Martin Nugent
01254 828060
D3/12/0185

**Planning Applications, Ribble Valley District
3/12/0185 Victoria Street Garage, Victoria Street, Clitheroe**

| Proposed<br>Site Plan                                                              |

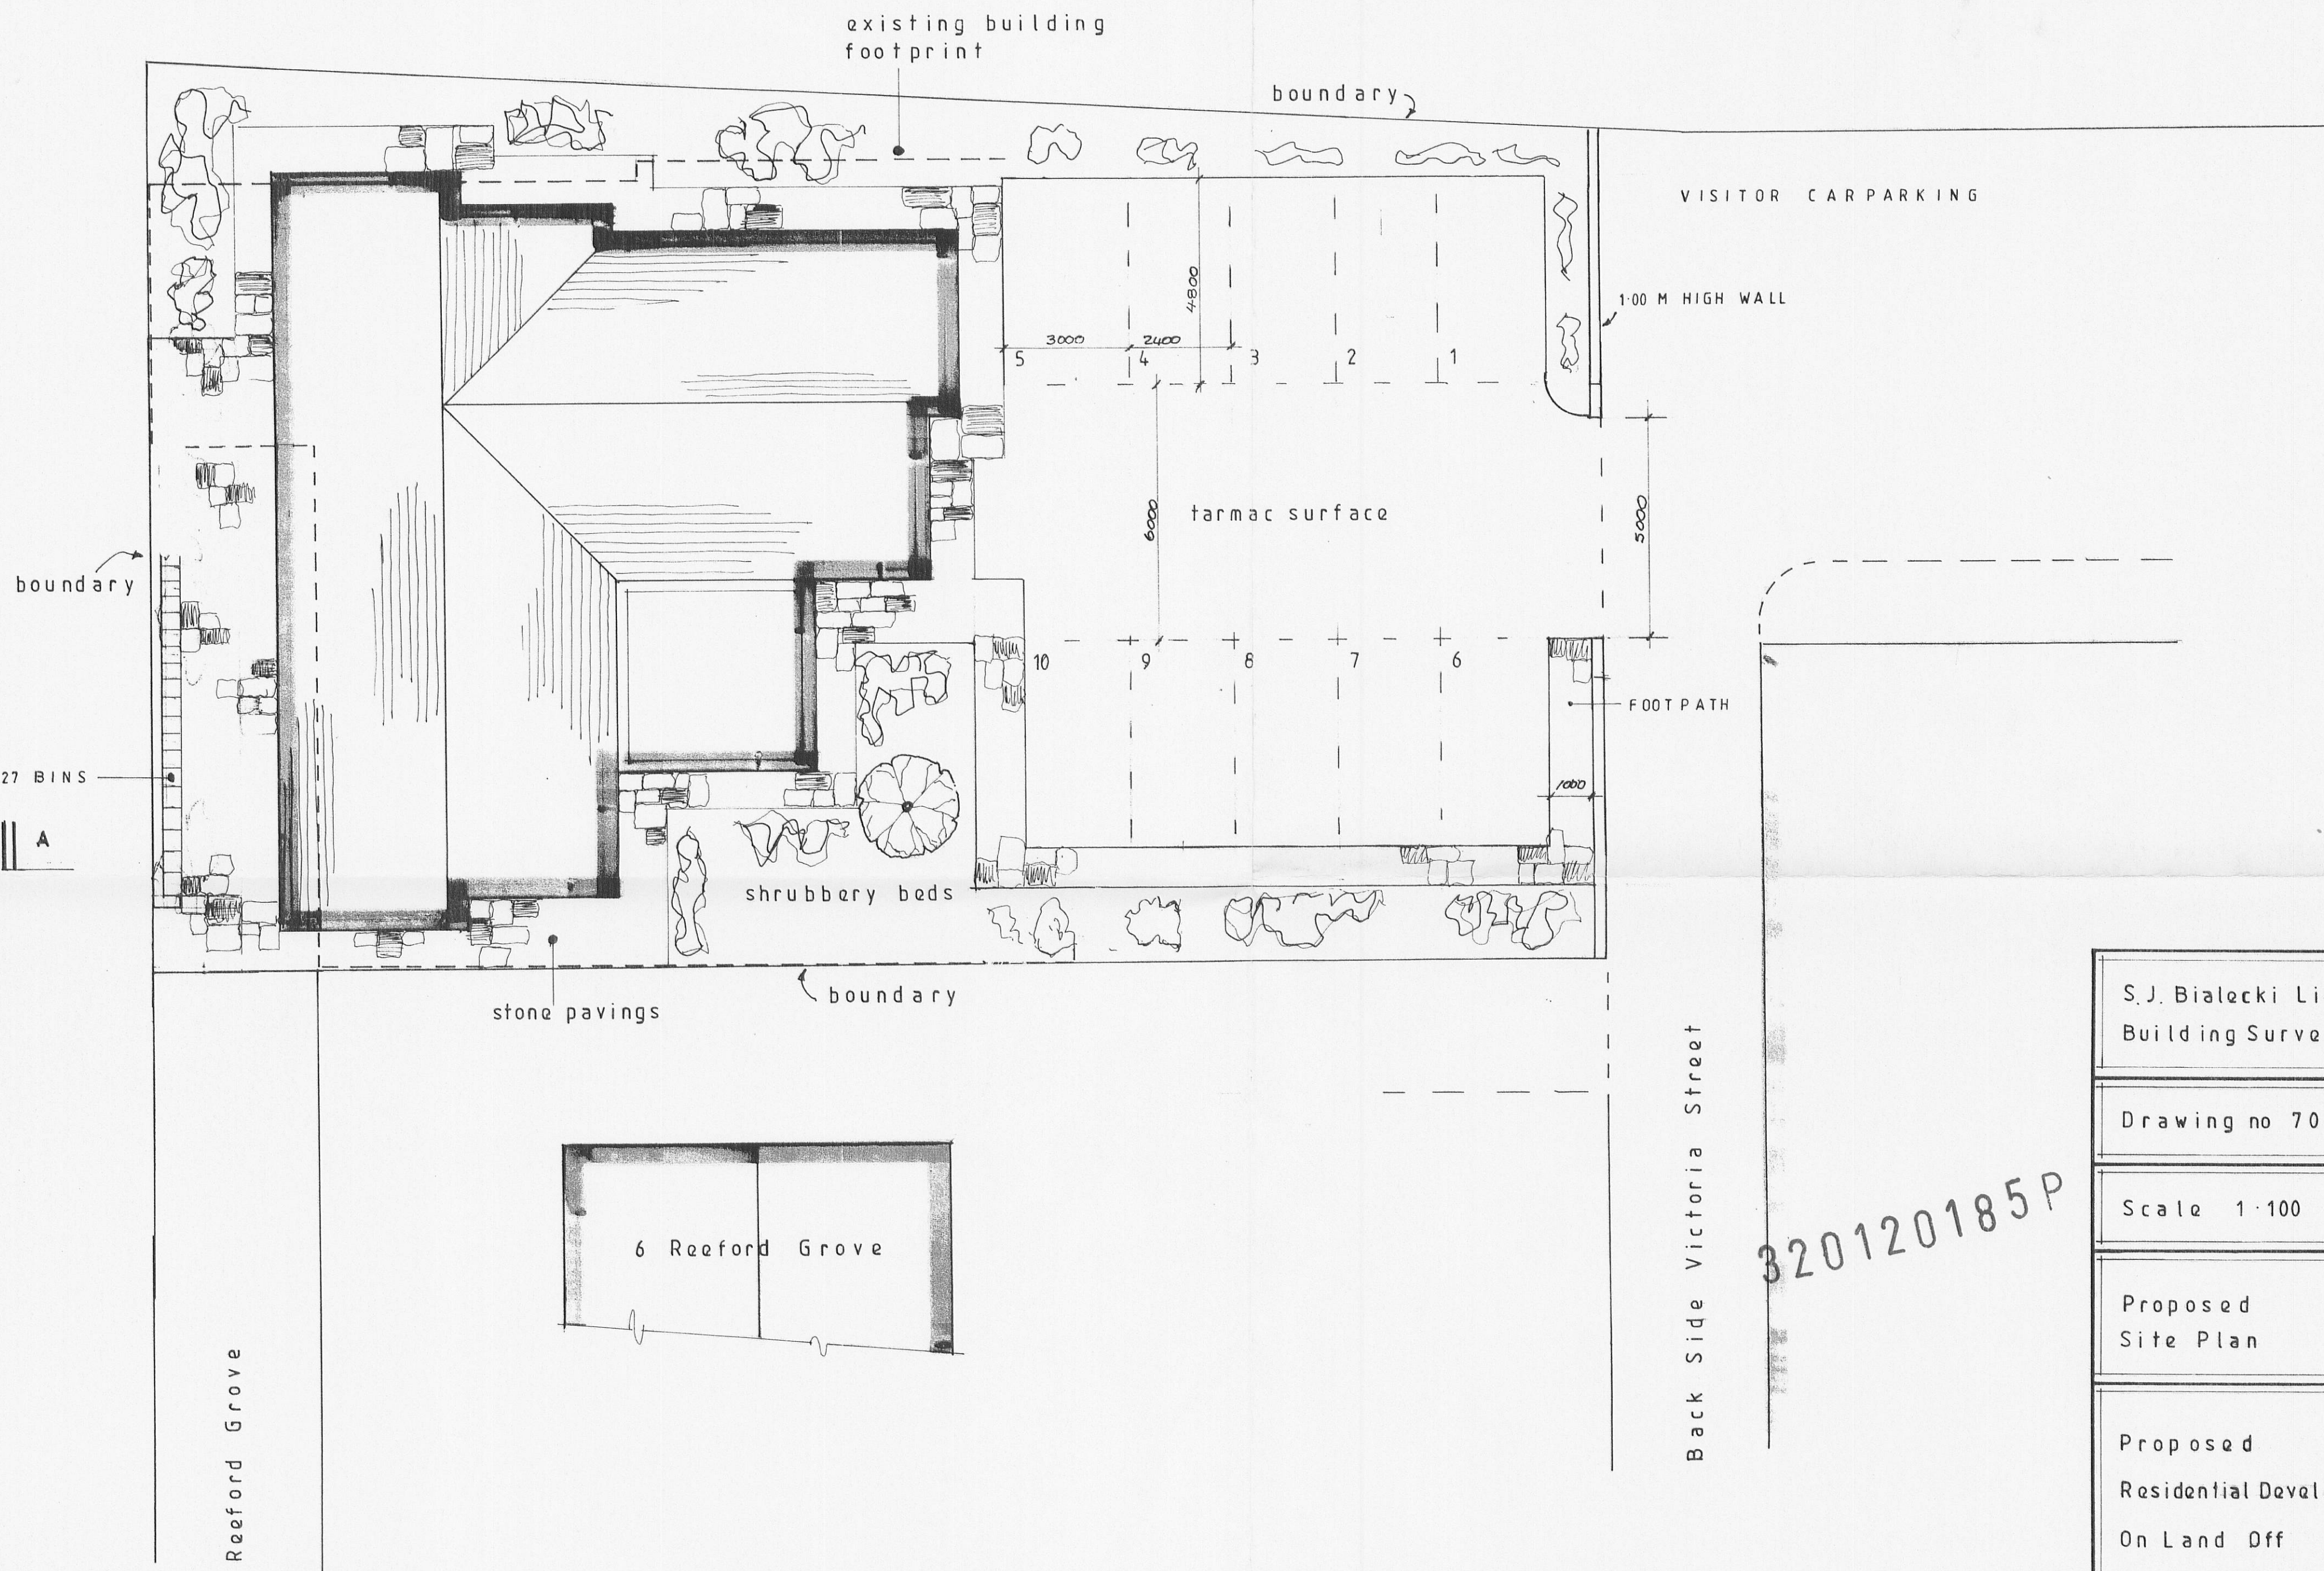
The layout of the parking spaces allows safe manoeuvring from the road and there is sufficient separation between the parking spaces and the boundary wall, directly adjacent to the carriageway.
